From: Ian Wightman [REDACTED]
Sent: 15 August 2019 17:49
To: Simon Davis <Simon.Davis@arun.gov.uk>
Cc: Chris Purdy (MHA) [REDACTED]; Harvey Hillary [REDACTED]; Martyn White [REDACTED]
[REDACTED] Harry Groucott (MHA) [REDACTED]
Subject: RE: Nyton House Care Home - AL/42/19/PL & AL/43/19/L

RE: Nyton House Care Home - AL/42/19/PL & AL/43/19/L

As part of the application to provide additional dementia care at Nyton House, Jane Jones Warner Associates were kindly asked to look at the proposals and offer some commentary on the scheme and consider potential solutions.

Proposed Elevations

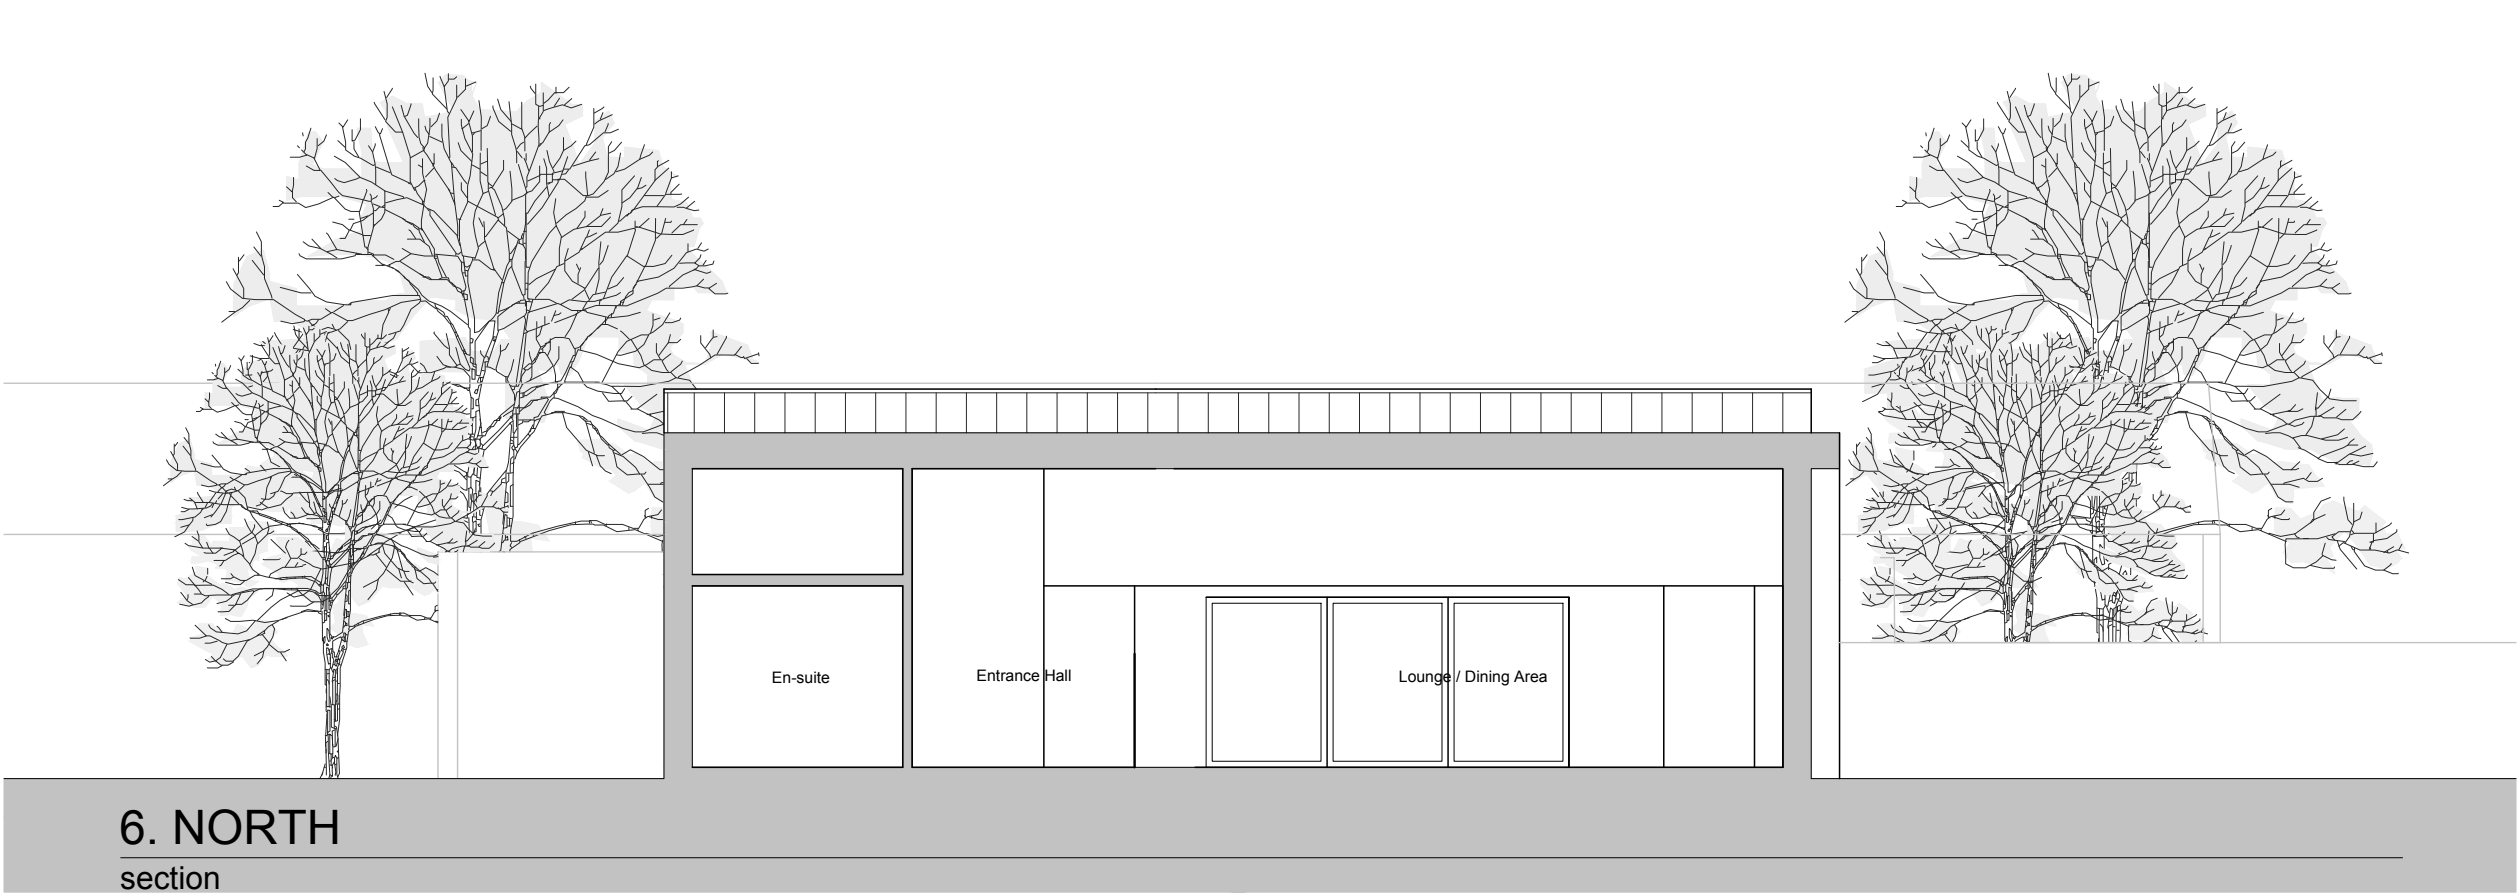
The design as it stood was largely as proposed now, with the exception of the roof which was gabled at both ends and thus clearly visible from Knighton Grange Cottage. Part of the problem here was the potential visibility of the gable ends and their visual impact on the large boundary wall which separates the two properties. The gable roofs created a saw-tooth type profile which was not sympathetic in this context.

The building form and scale is clearly subservient to the neighbouring historic buildings and does not compete with them. As can be seen in the west elevation especially, the new development is low level.

The solution here was to hip the roofs and thereby push the ridges back so that they were less intrusive. The hipping also resulted in a more recumbent and quieter roof form that turns its back on the cottage and it is therefore much quieter in visual terms. Whilst the roofs would still be visible, the use of good quality clay tiles would be appropriate in this context.
